DECISION DELEGATED TO HEAD OF PLANNING

Application No: H09-0503-24 **Applicant:** Mr & Mrs R Frost
Proposal: Raising of roof structure to existing bungalow to form first floor
Location: 3 Vicarage Close Holbeach St Johns Spalding
Terminal Date: 31st July 2024

REV:	DESCRIPTION:	DATE:
PROJECT: CONVERSION OF BUNGALOW TO 1+2 STOREY DWELLING		
DRAWING: PROPOSED FLOOR PLANS PROPOSED ELEVATIONS		
SIZE: A1	CLIENT: Mr & Mrs R. Frost	
SCALE: as labelled	DRAWING BY: JC	SHEET: 0448/24/02

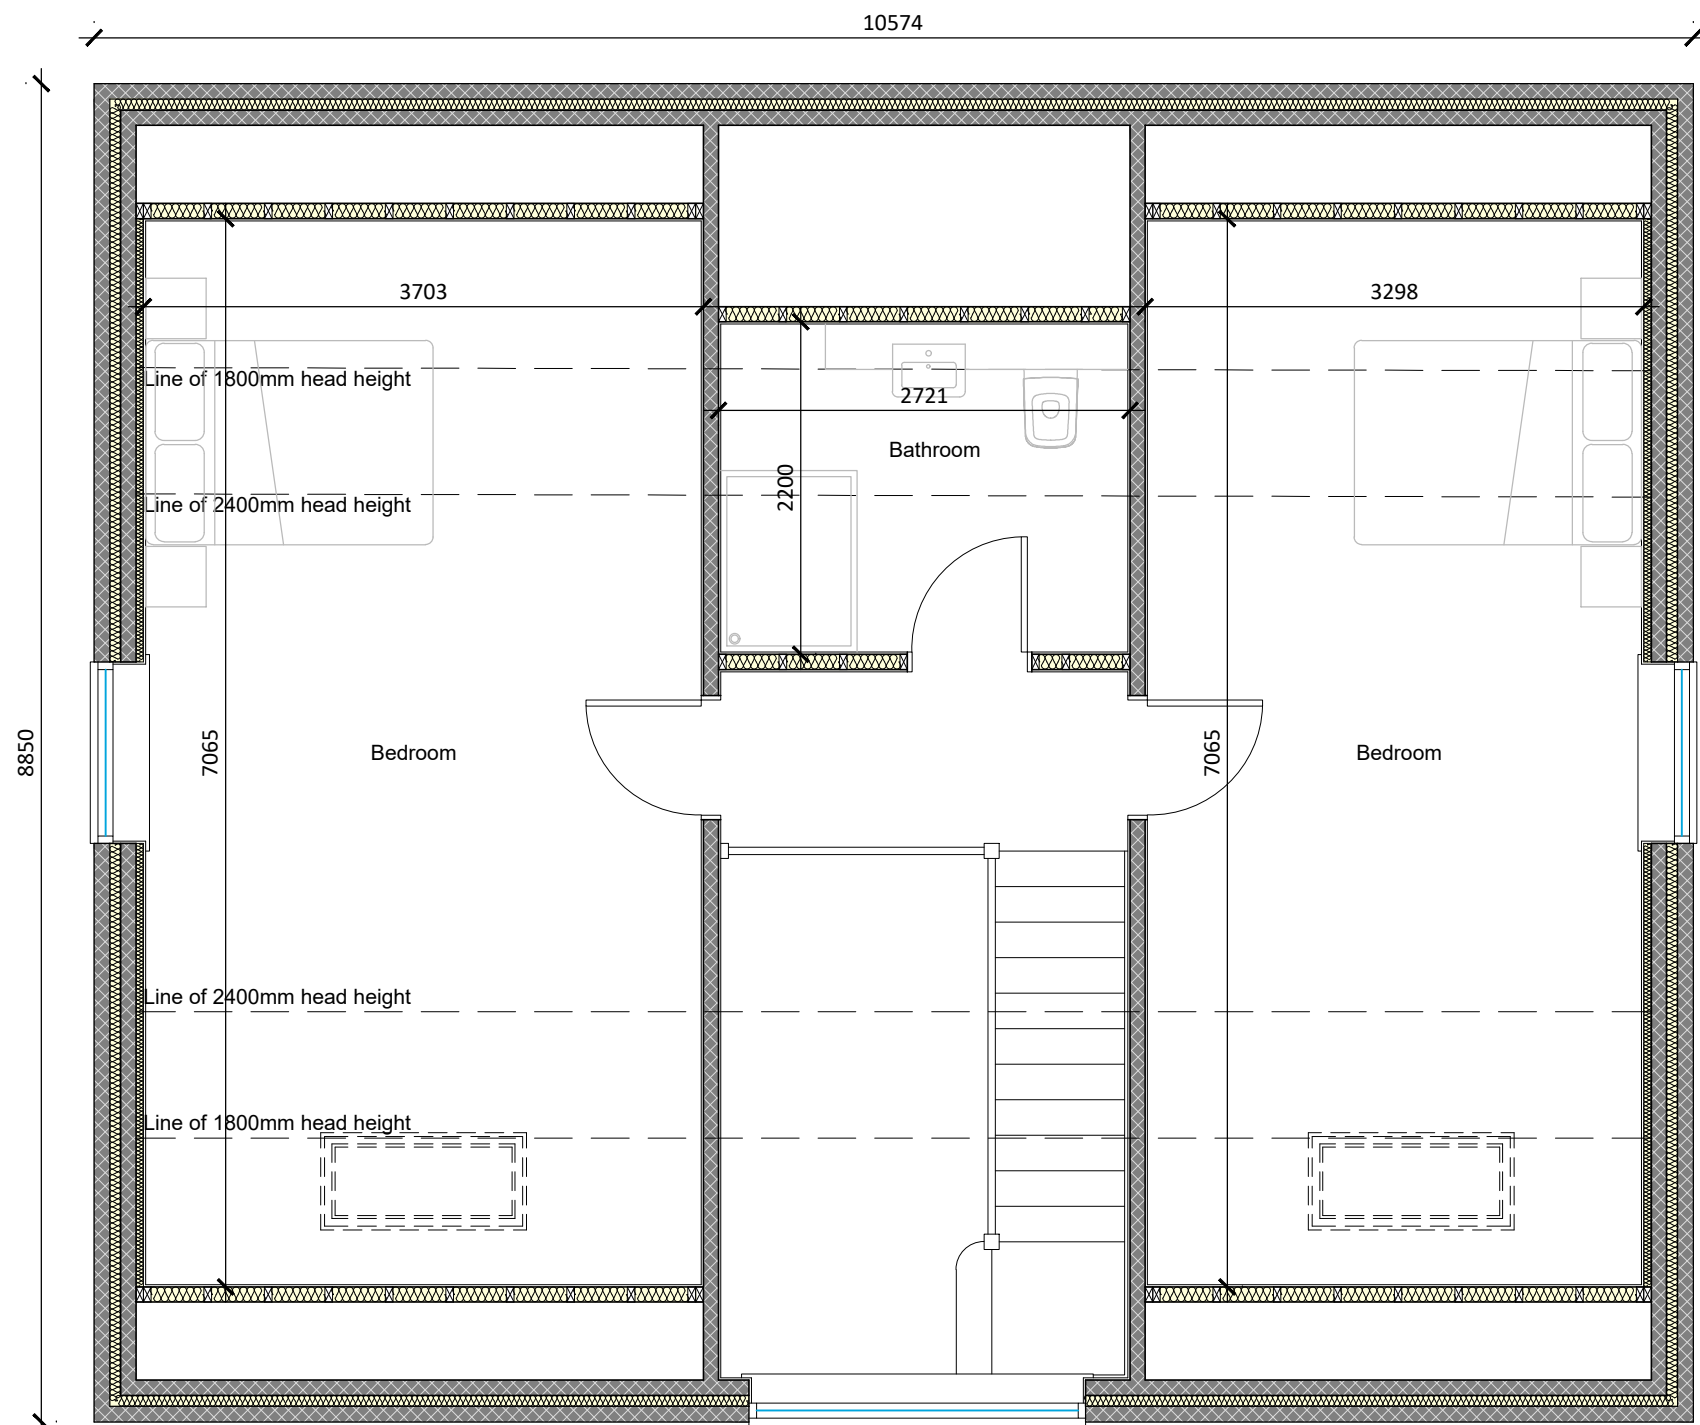
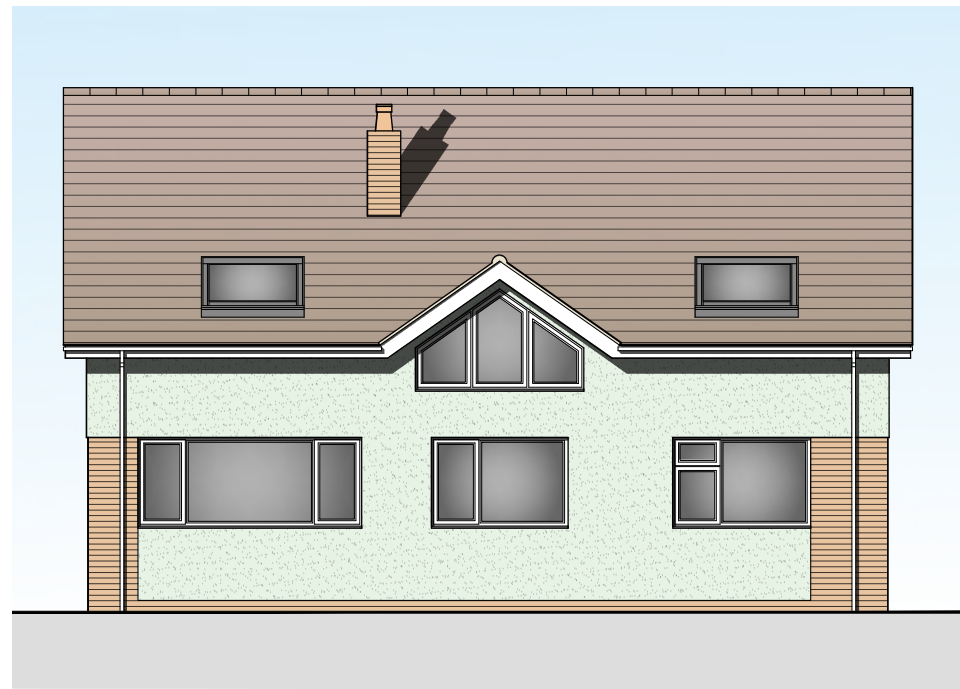
design of the roof would be consistent with what is currently in situ. The extension would raise the height of the eaves from 2.4 metres to 3.4 metres, with the ridge height increasing from 4.6 metres to 6.8 metres. The first floor would be rendered cream/sage green. All other materials would match the host. The works would result in two additional bedrooms.

The proposal would introduce a window in the northern and southern elevations at first floor level. Both of these windows would face onto neighbouring properties. That being said, the southern window would look purely into the front garden of 4 Vicarage Close, thereby not representing an overlooking concern that would cause a significant detrimental impact.

While the proposal is located in close proximity to 2 Vicarage Close, located to the north, it is not considered that the proposal represents a significant overshadowing concern. The majority of overshadowing created would fall upon a blank elevation of 2 Vicarage Close, ensuring that no significant impact would occur. Light levels reaching the bifold doors to the rear of this property would be reduced marginally; however, the impacts of this loss of light would not be significant enough as to warrant a refusal.

While there is an existing window on the site facing north, due to its positioning, this offers limited views into 2 Vicarage Close. In moving the window upwards, by approximately 1 metre, the proposal would increase the risk of overlooking. This is potentially particularly impactful as the alteration may result in some views into the corresponding window of 2 Vicarage Close. To prevent this, it is recommended that, if permission is granted, a condition be imposed requiring the window to be obscure glazed and non-opening.

As the proposal would increase the number of bedrooms on the site to four, an additional parking space would be required. It is considered that there is ample room within the site to accommodate this additional parking.
